London Luton Airport Expansion

8.11 Statement of Common Ground between London Luton Airport Limited and National Highways (Tracked Change Version)

**8.11 STATEMENT OF COMMON GROUND BETWEEN LONDON
LUTON AIRPORT LIMITED (TRADING AS LUTON RISING) AND
NATIONAL HIGHWAYS (TRACKED CHANGE VERSION)**

Deadline:	Deadline 3
Planning Inspectorate Scheme Reference:	TR020001
Document Reference:	TR020001/APP/8.11
Author:	Luton Rising

16.5m Articulated HGV  
Swept Paths At Junction 10  
of the M1 with 2039  
27mppa Mitigation Scheme  
Scale 1:1000 at A1  
Drawing Number - SK053

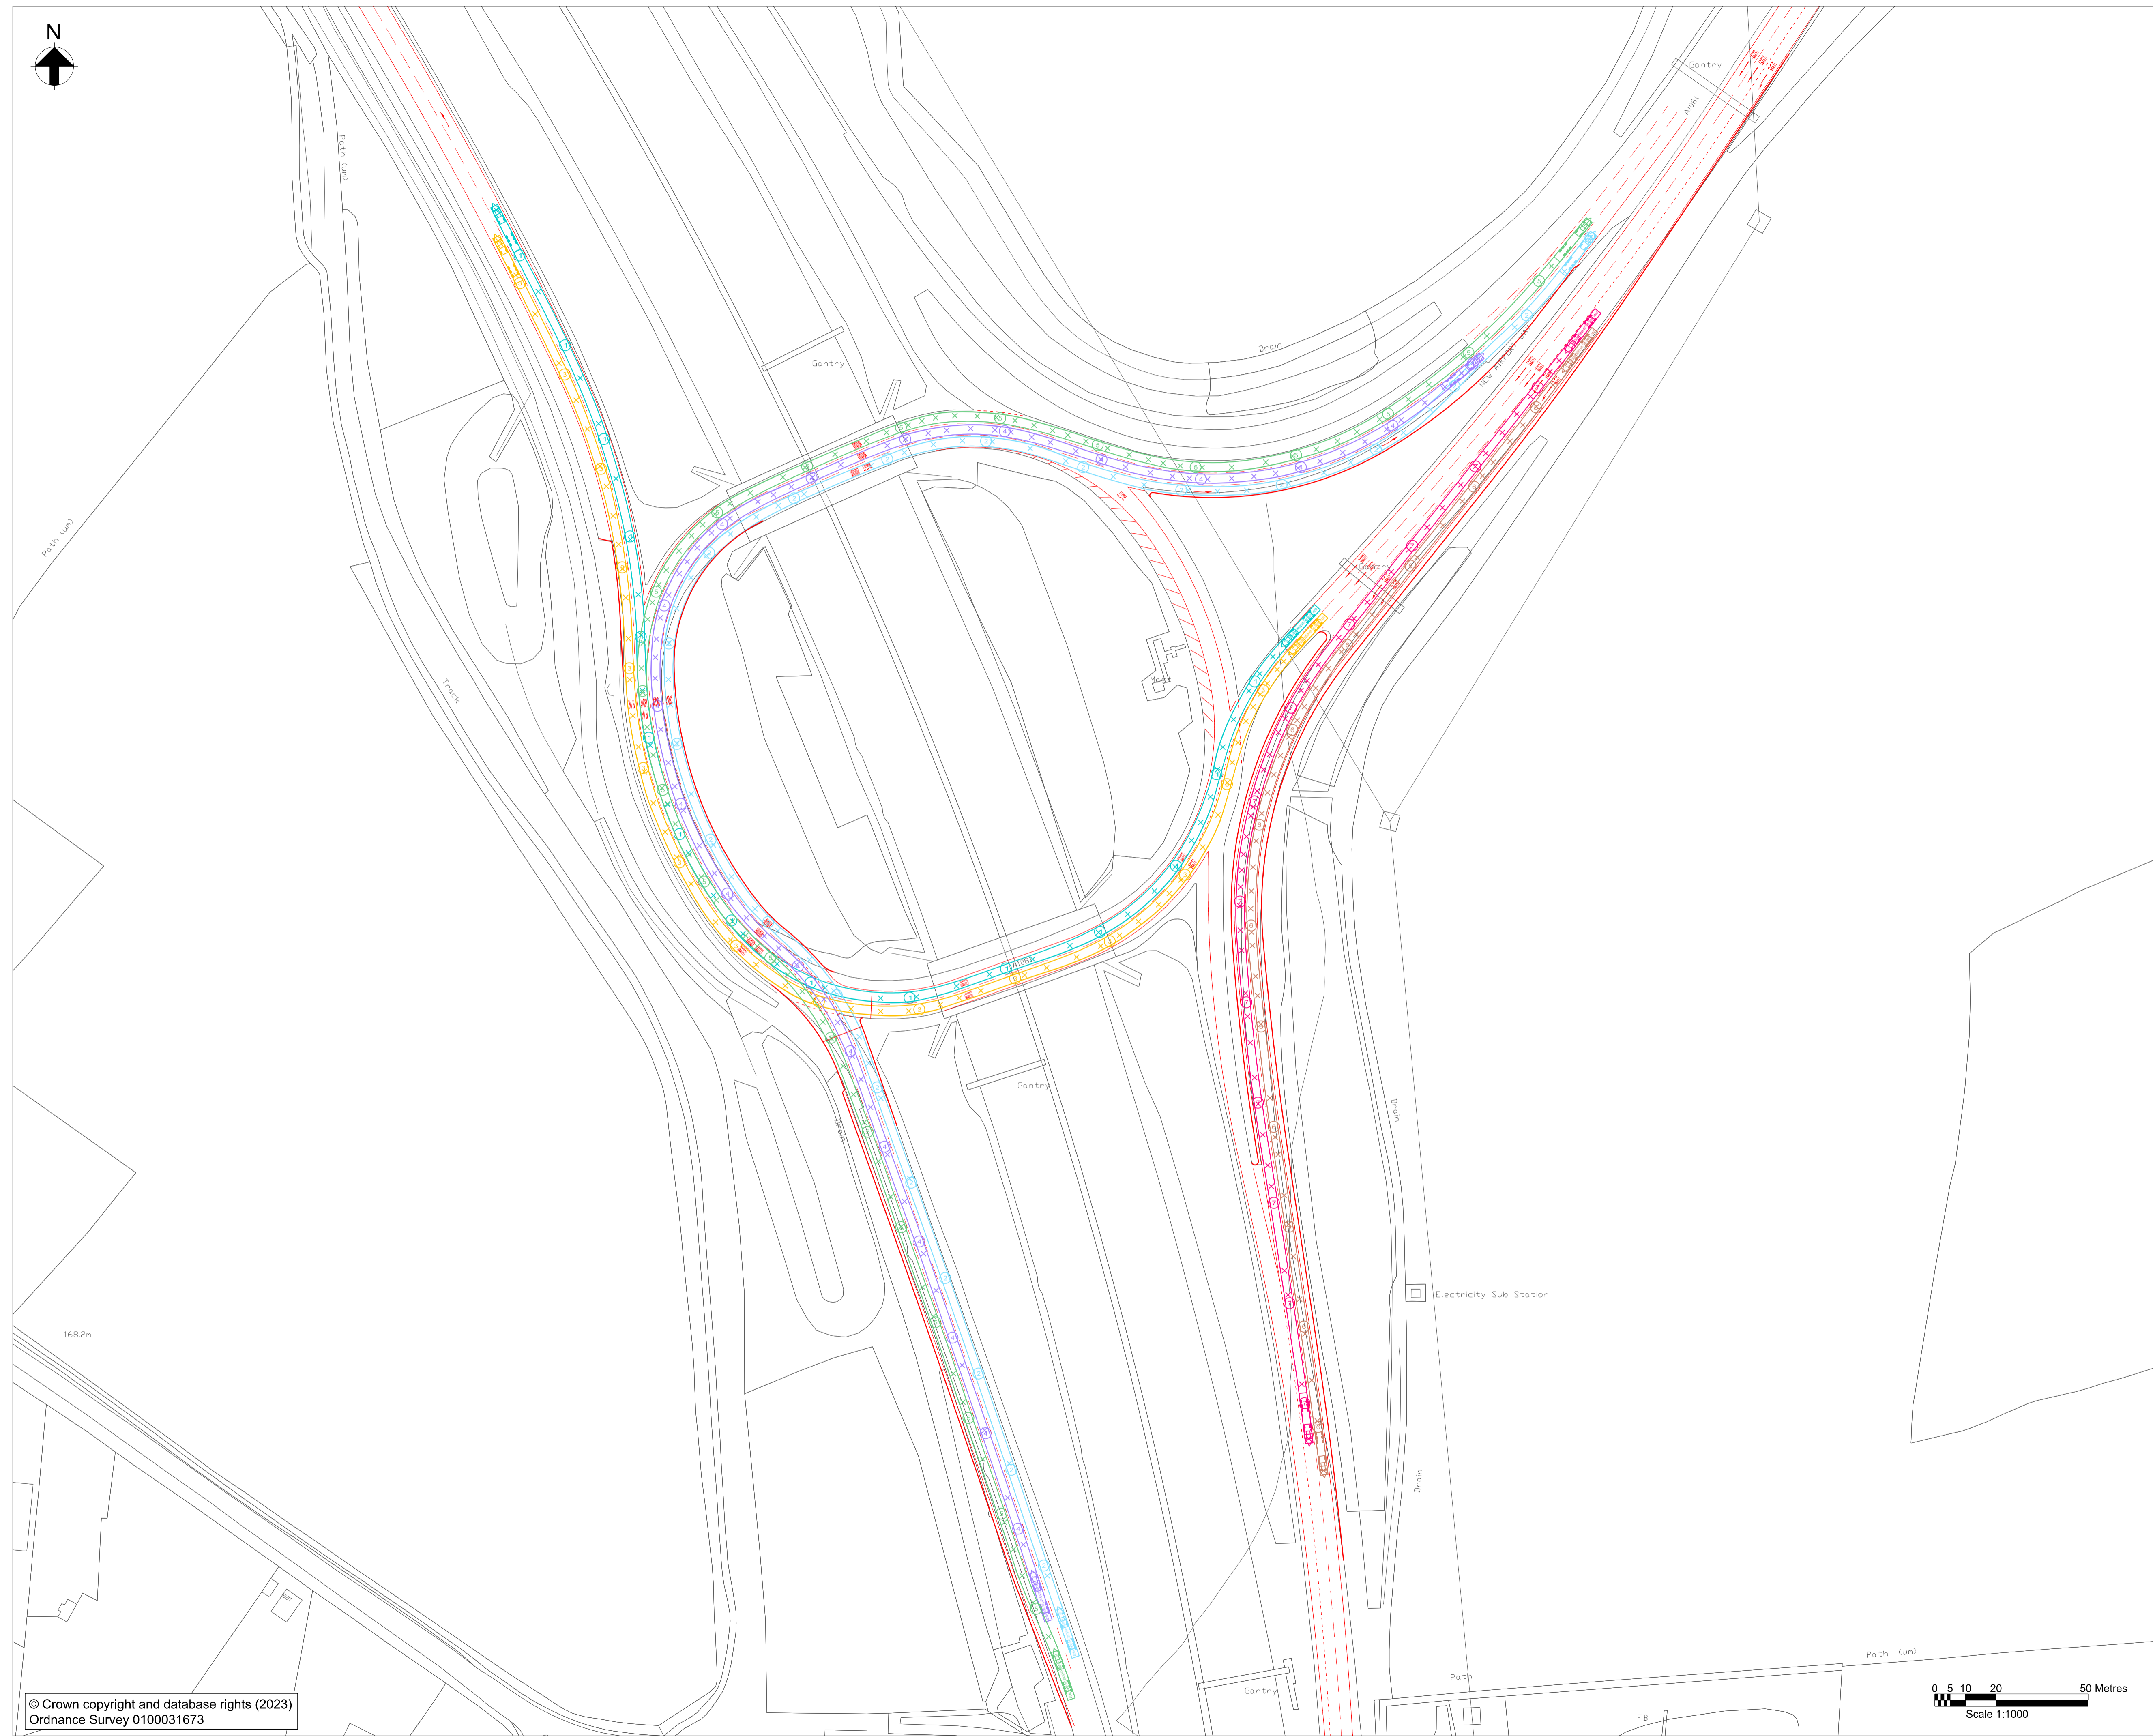
3.2.5	Junction 10 enhancements – lane widths	It is important that lane widths within the curved section of the circulatory are able to accommodate HGV swept paths without cross-lane encroachment.	<p>Tests have been undertaken to ensure that the proposed circulatory lane widths are able to accommodate side-by-side HGV movements and further information can be provided to National Highways to confirm this.</p> <p>Where appropriate and/or necessary, the Applicant will provide an updated response at Deadline 3.</p>	Ongoing
